Submission – Taronga Zoo Sky Safari (SSD-46807958) - Amendment

Thank you for the opportunity to provide comment in response to the amendments to State Significant Development Application (SSD-46807958) for the Taronga Zoo Sky Safari that is on public exhibition until 10 June 2025.

4 PLAN - PYLON 5
1 : 100

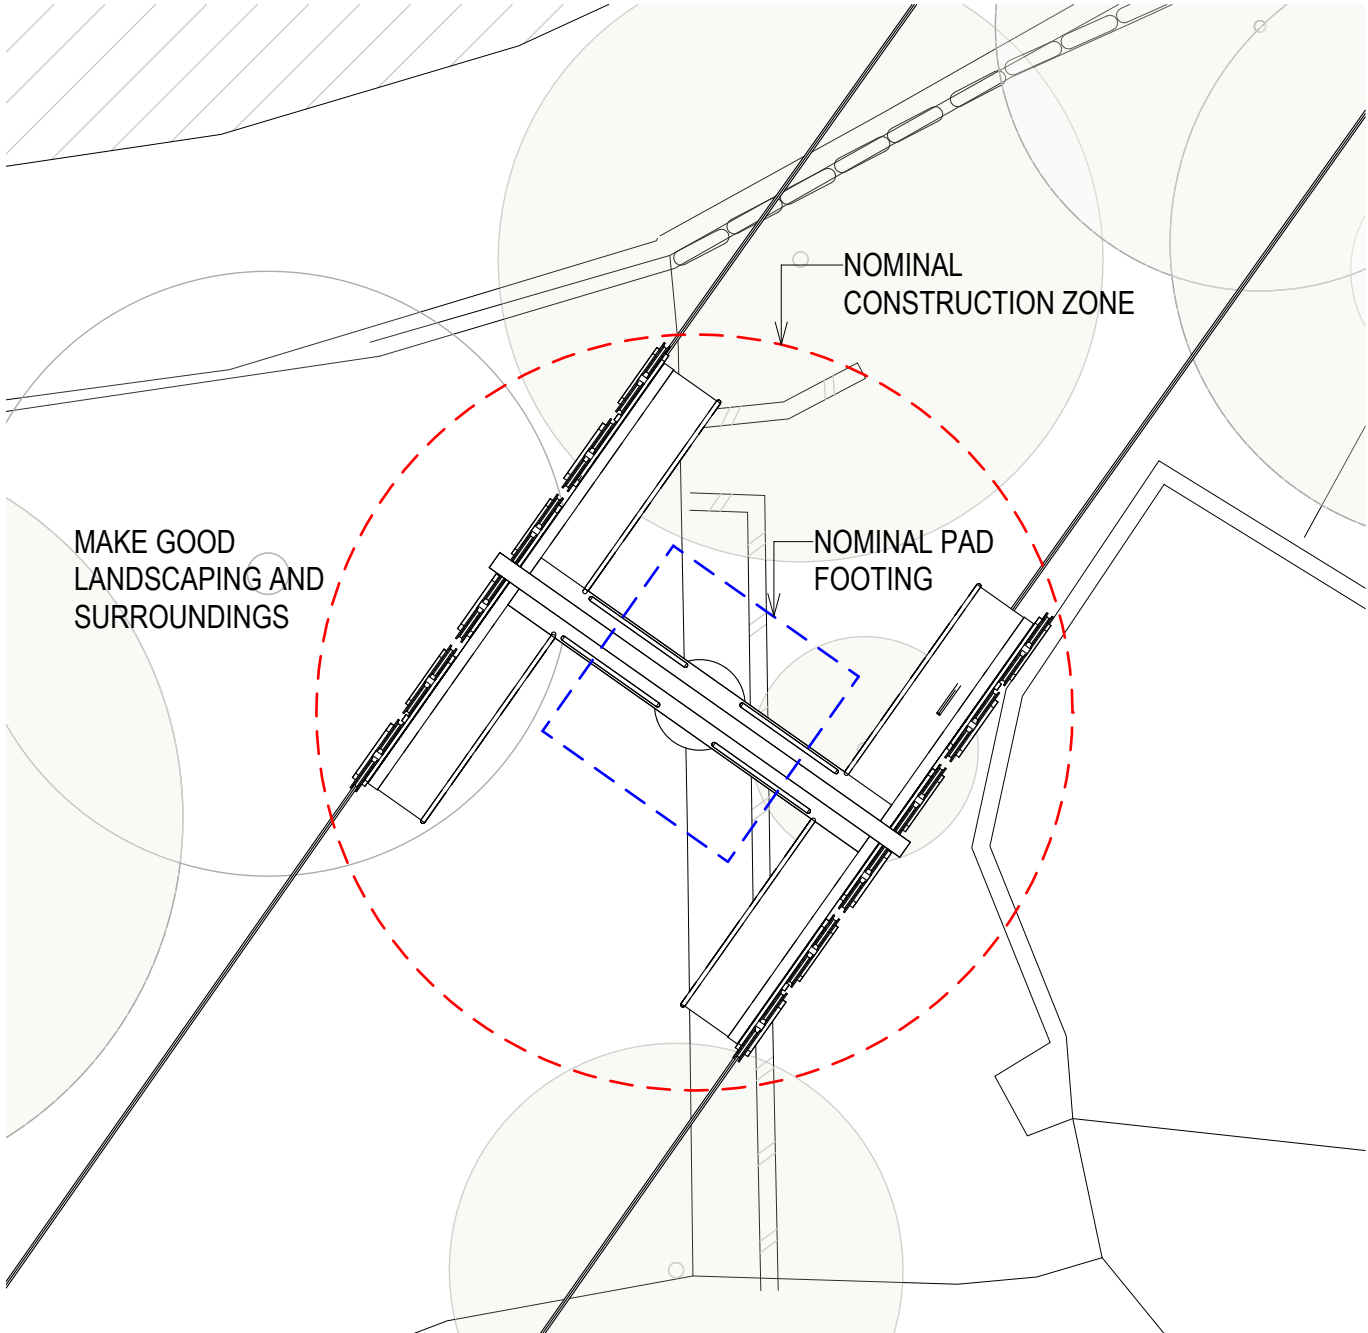
Council also requests that the height of Upper Pylon 5 be reconsidered for potential reduction, given the increased scale and expanded footprint of the Lower Station. With additional built form introduced at the base of the system, a design-sensitive adjustment to the upper pylon would help reduce cumulative visual impact and better balance the project's overall scale. This request is further supported by the fact that the Visual Impact Assessment excluded the gondolas, despite their ongoing visibility and movement across the route, which limits the ability to fully assess their contribution to the project's total visual presence.

Council also notes that the Visual Impact Assessment relies on long-term tree growth to screen the visibility of pylons such as Upper Pylon 5. This limits short- to medium-term mitigation and may leave key structures visually exposed for decades. In addition, the potential to reduce pylon height through selective pruning of existing tall trees, such as Hoop Pines, appears under-explored. This should be investigated further to determine whether visual bulk can be reduced through non-invasive vegetation management prior to construction.
